**Sydney Children's Hospital Stage 1 and
Children's Comprehensive Cancer Centre (SSD-10831778)
Response to submissions**

Attachment 1

Level 04 Landscape Plan

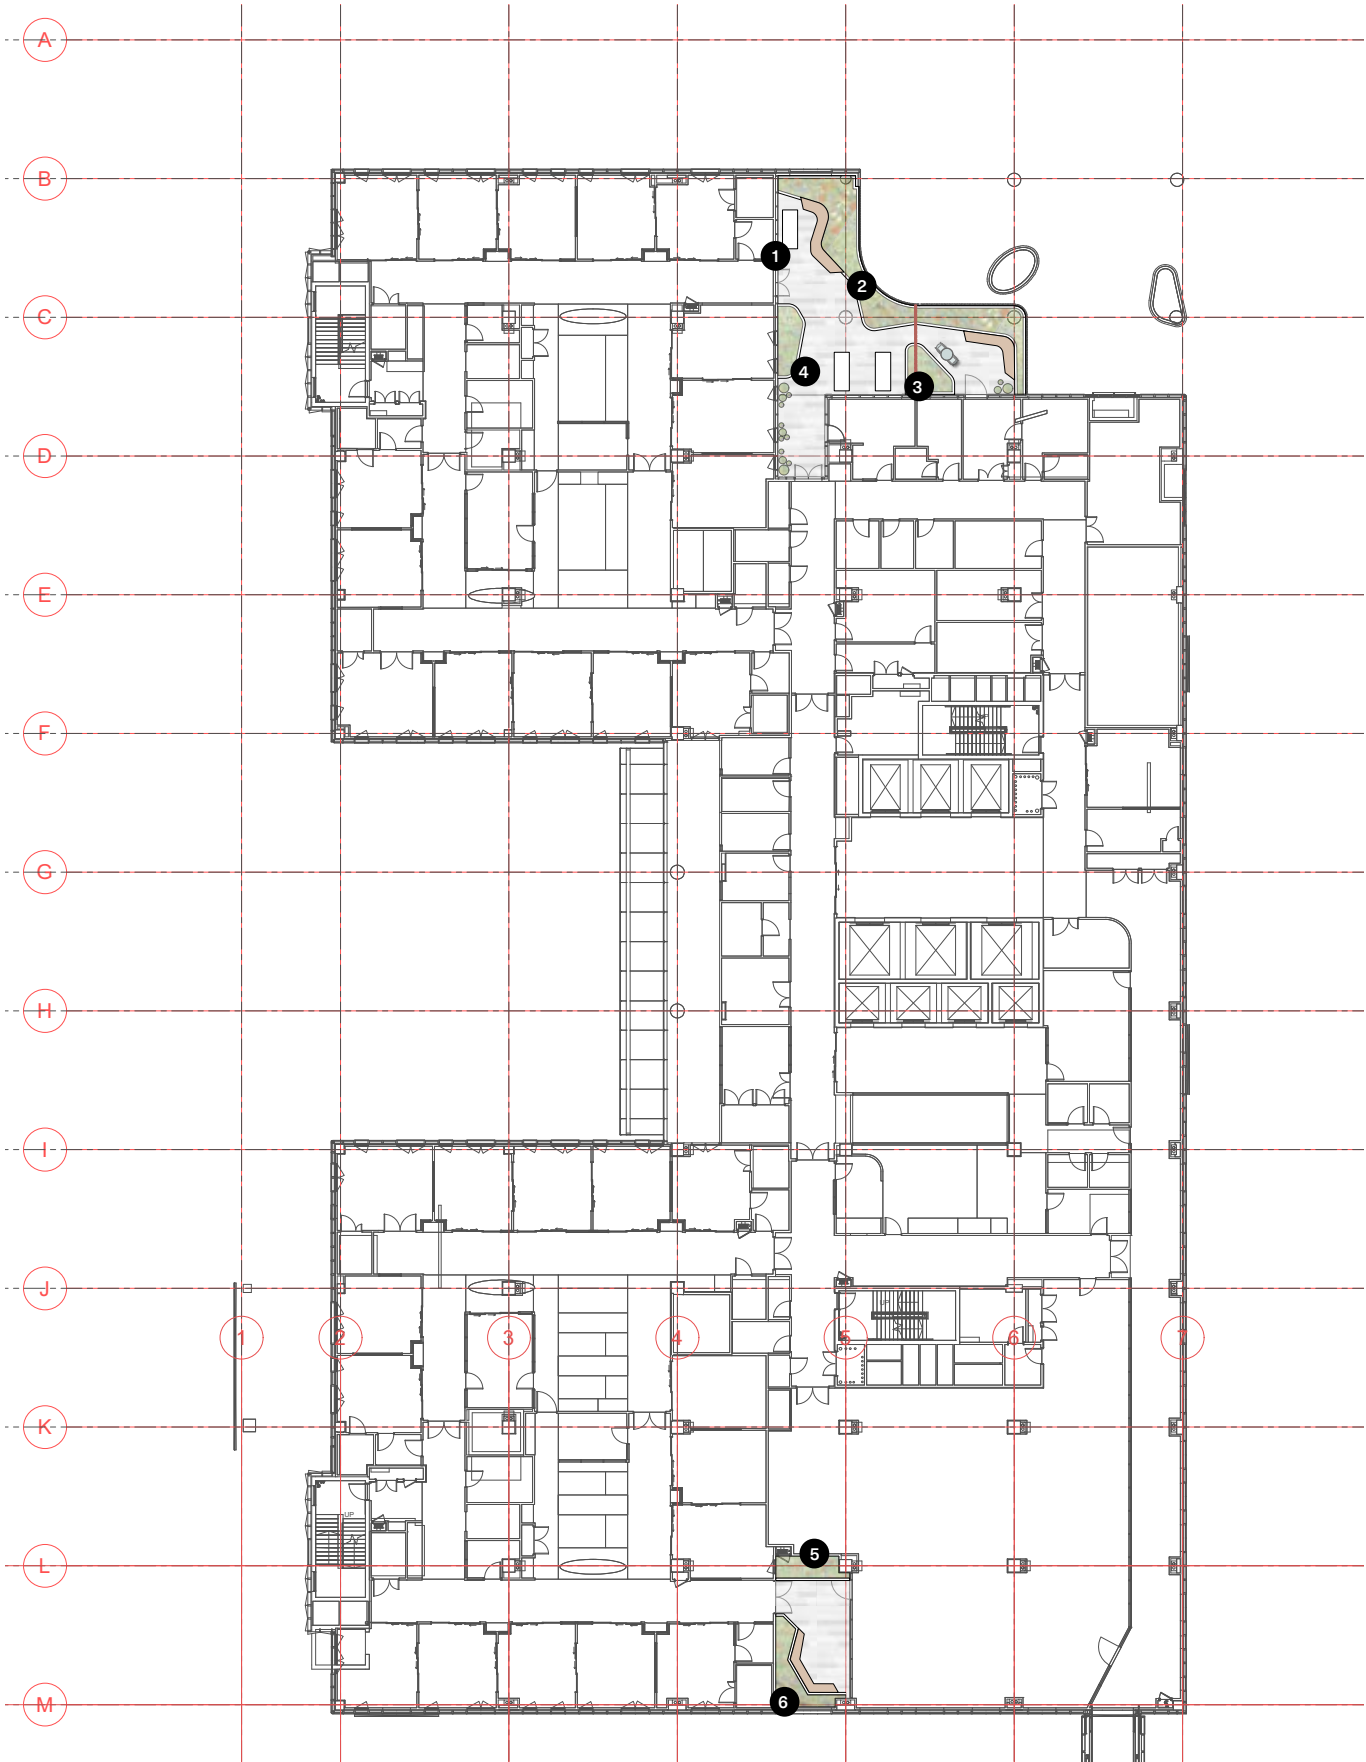
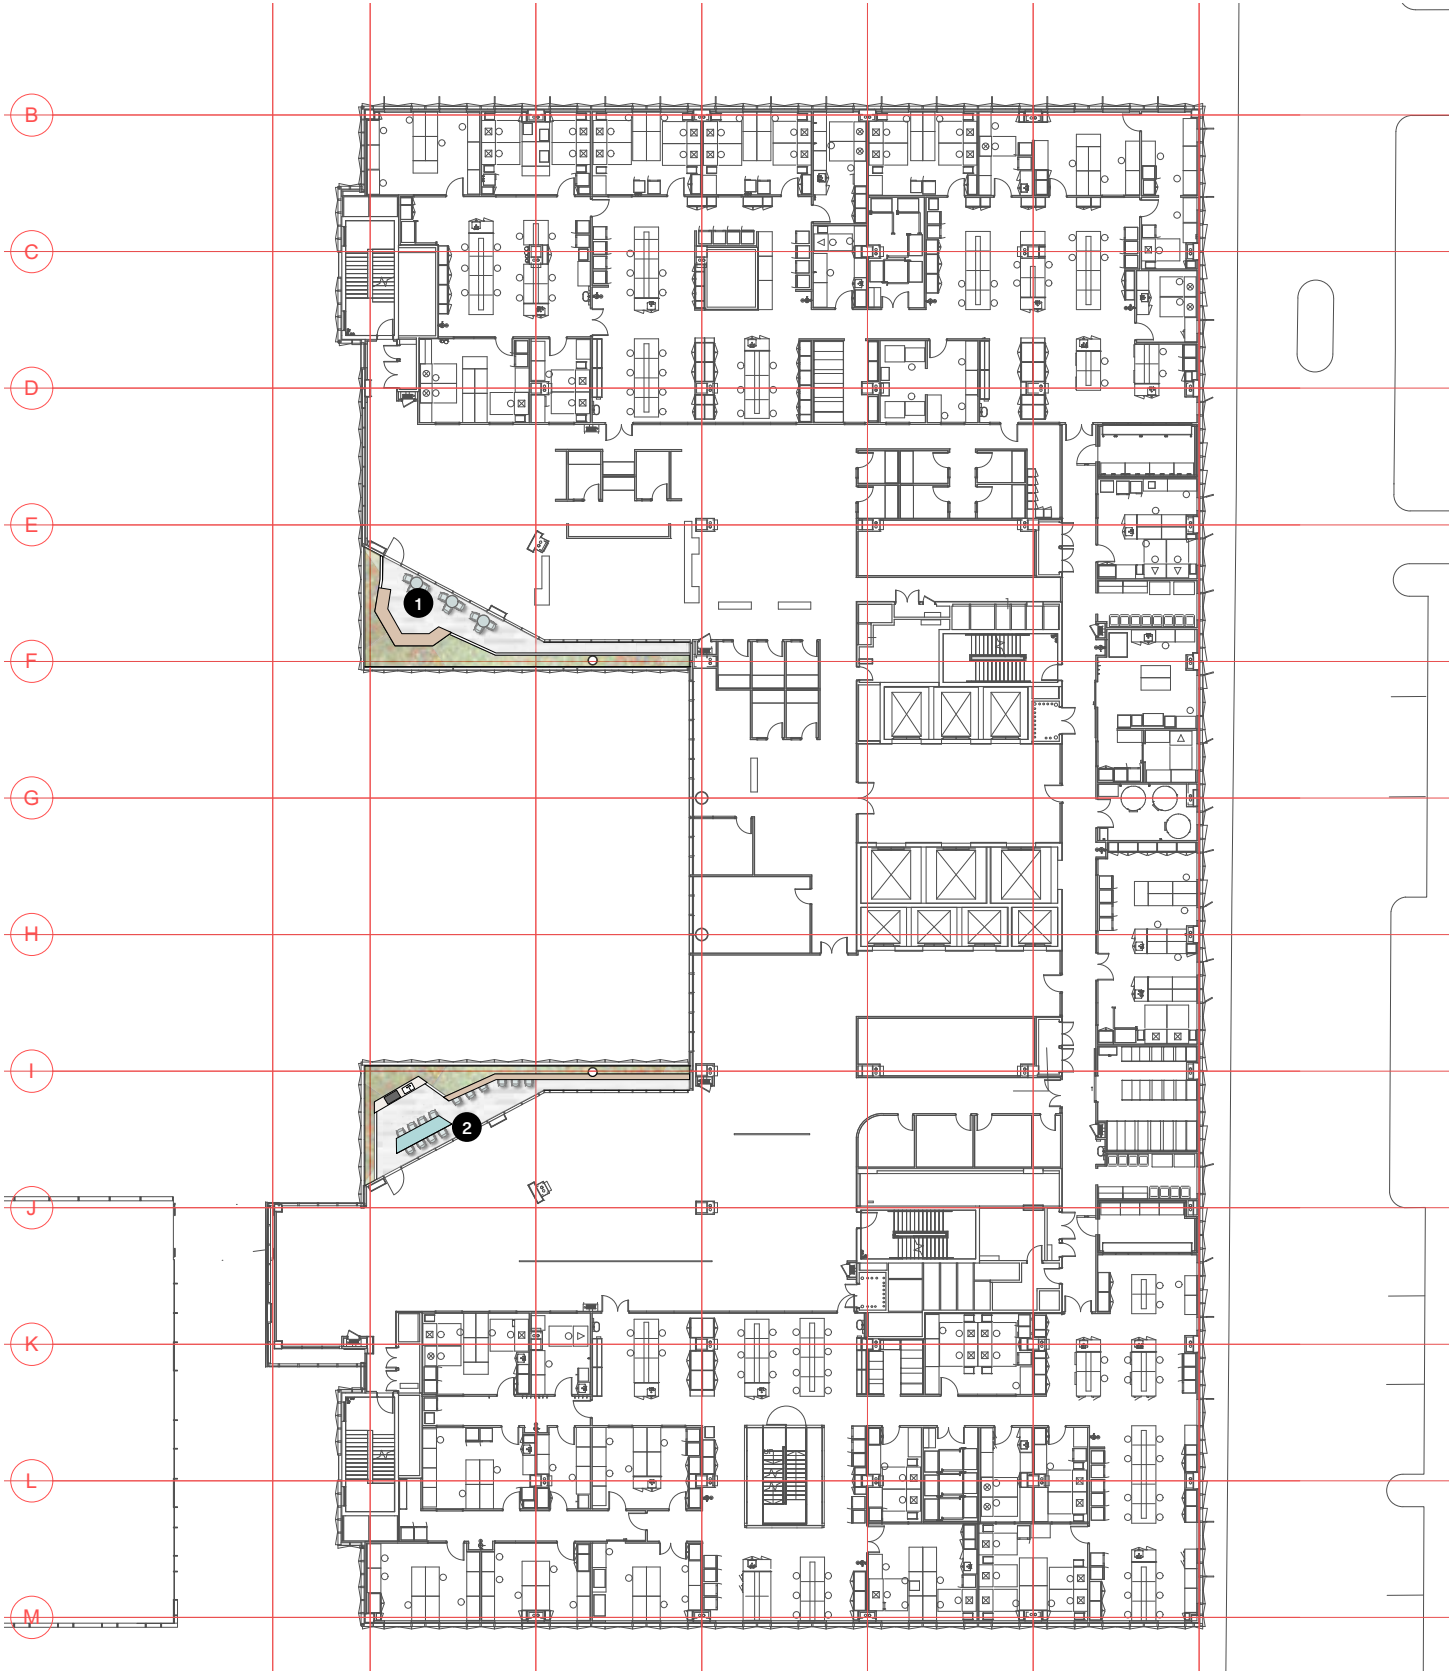
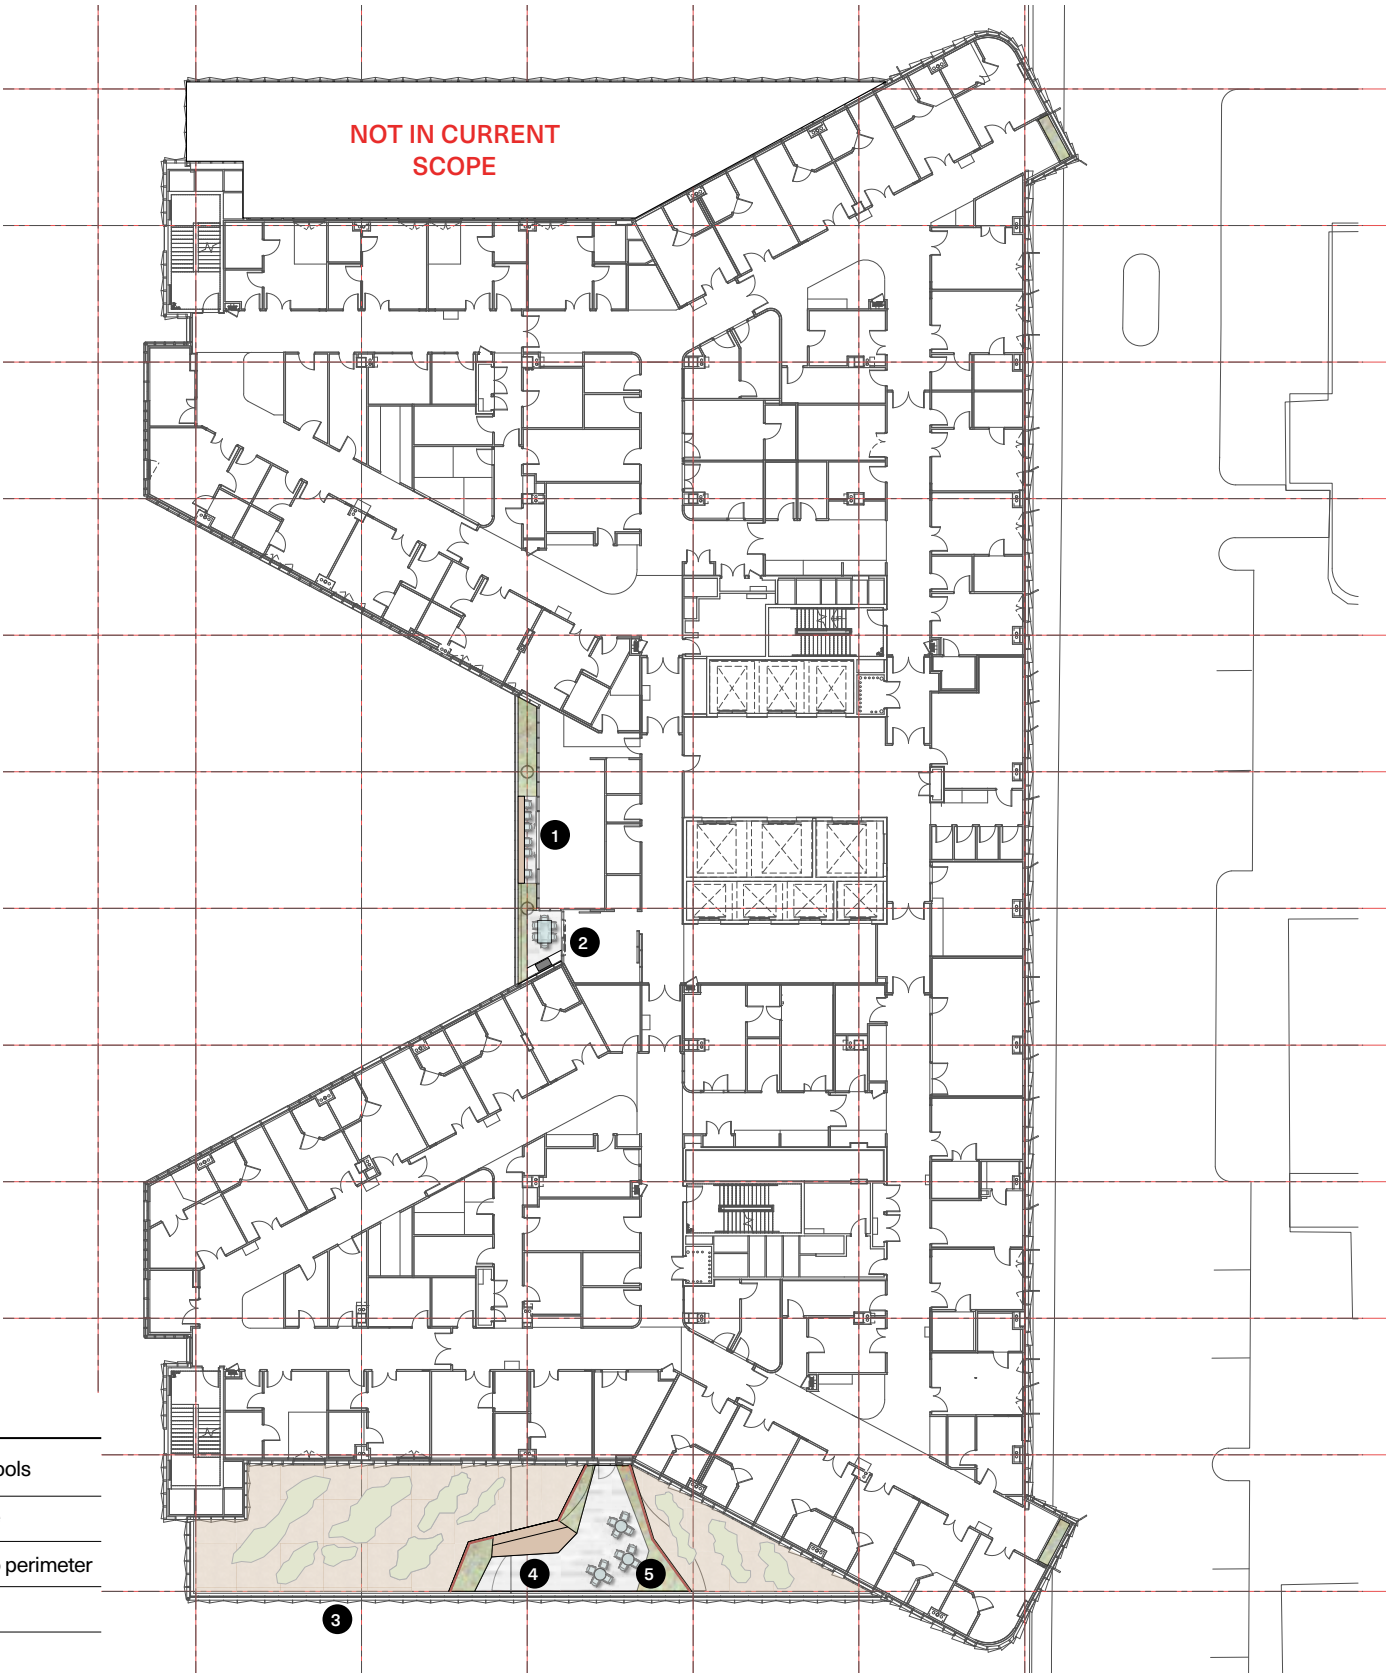
- Visualisations indicate landscaping to upper levels terraces and utilisation of podium roof areas for landscaping but no details are provided on the landscape plans. Landscape plans should be updated to include these areas and demonstrate provision of high quality outdoor spaces for occupants of the building and to assist with offsetting any shortfall in tree canopy cover.
